Your Ref
A/136/15/HH
Our Ref
PLAN-011354
Date
16/10/2015

Proposal: Single storey rear extension.
Site: 46 Ashurst Way, Angmering, BN16 1AG.
A/136/15/HH

C		
B		
A UPDATED FOR PLANNING APPLICATION SEPT 15 B		
Client	L. Mehmedovic Esq.	
Address	46 Ashurst Way : East Preston	
Drawing	Extension	No. 6315 : 1A
Scale	1:50 1:100	Drawn B
		Date AUG 15

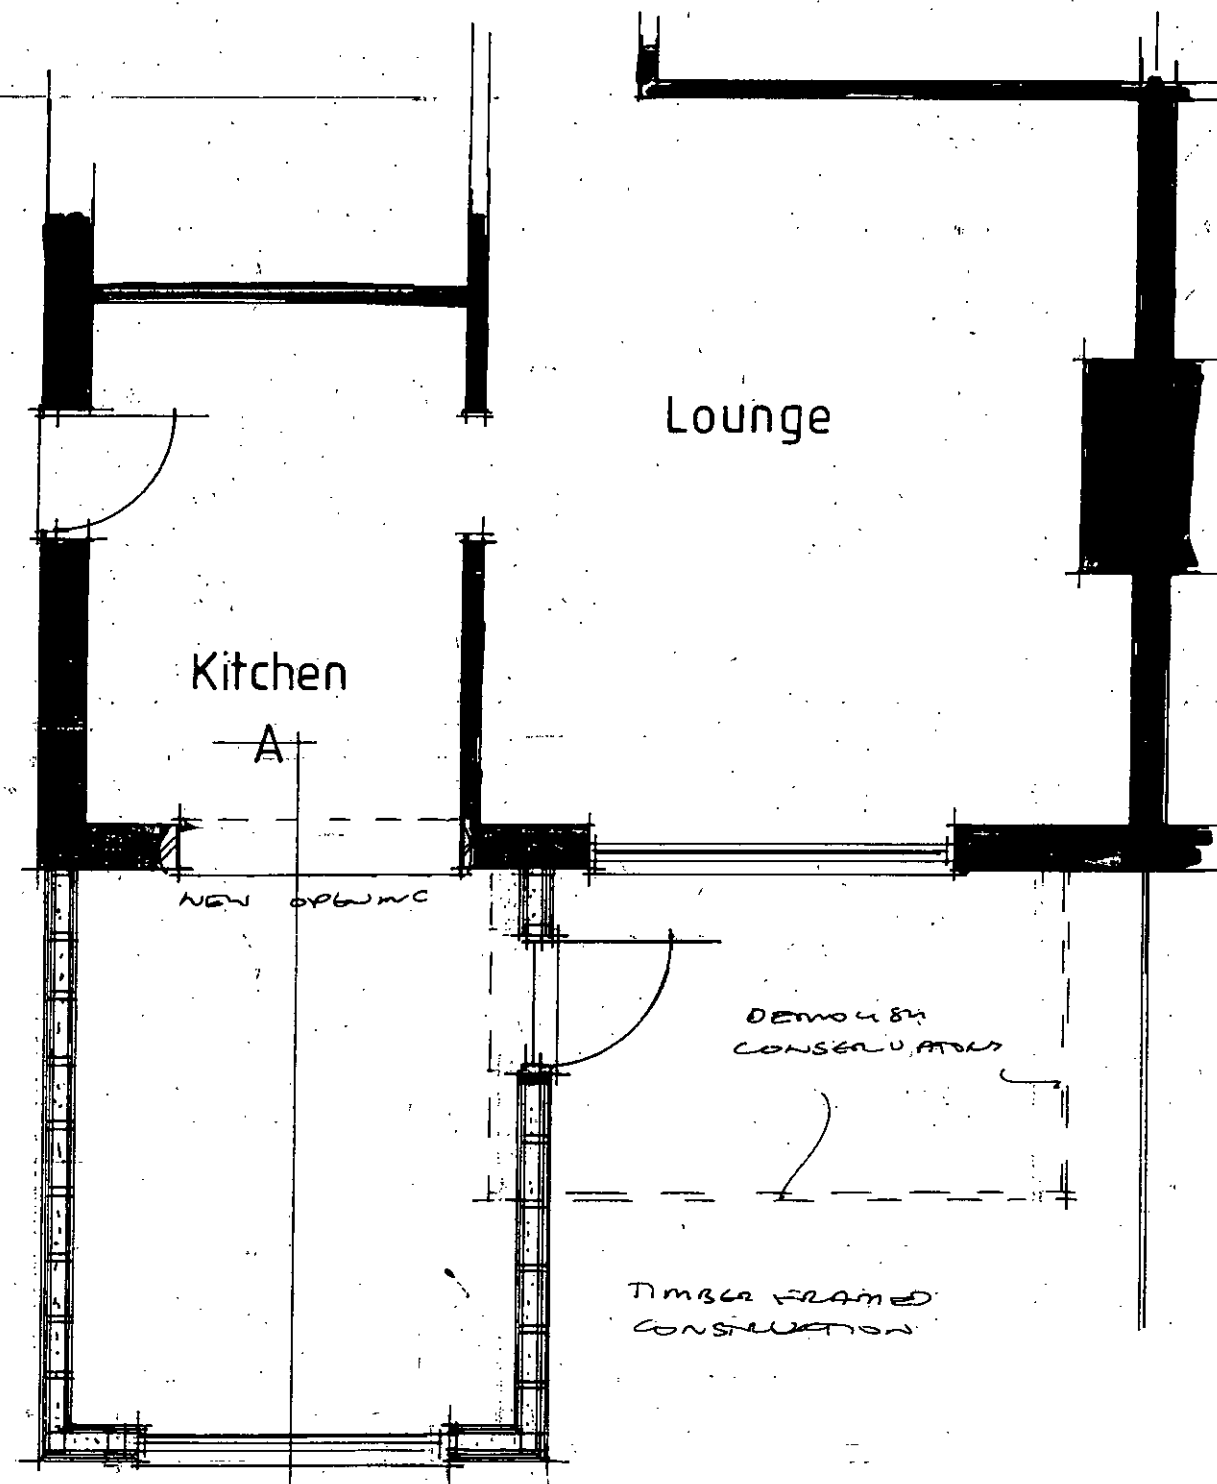
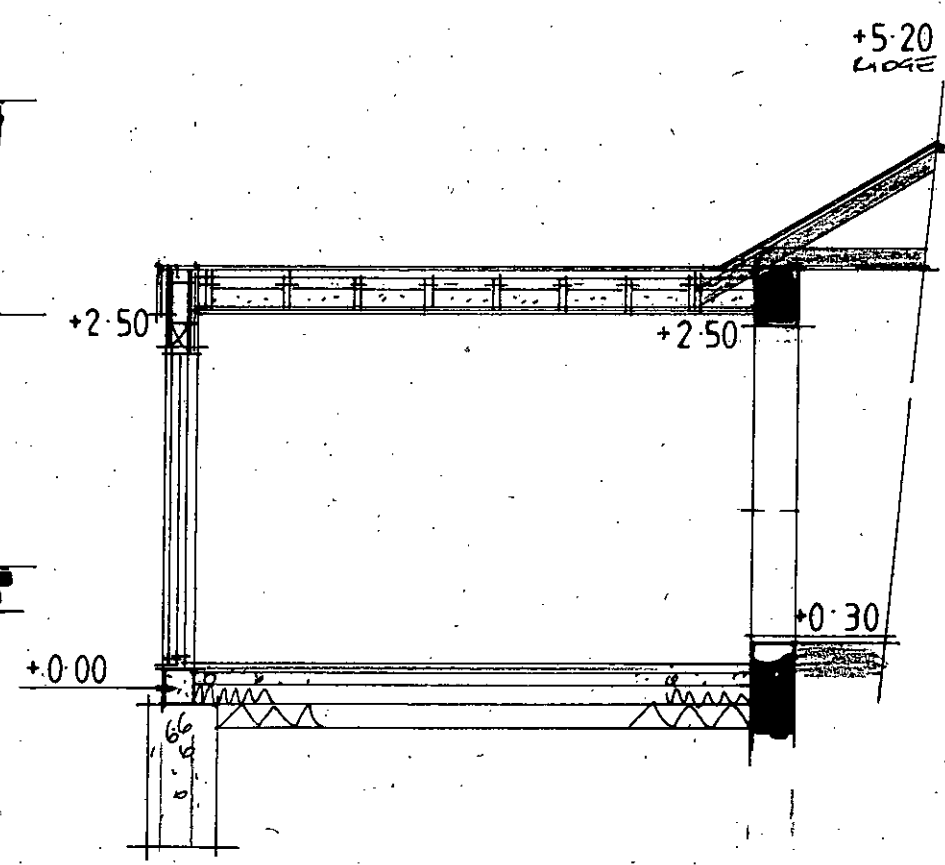
It appears that the developer is intending to build over a public foul sewer which is crossing the site. Building over a "public sewer" is not normally permitted by Southern Water.

However, under certain circumstances building over a sewer may be allowed. The conditions associated with the build over to a sewer are contained in Southern Water guidance notes which are available at: www.southernwater.co.uk. A formal application to build over to the sewer will required to be submitted by the applicant."
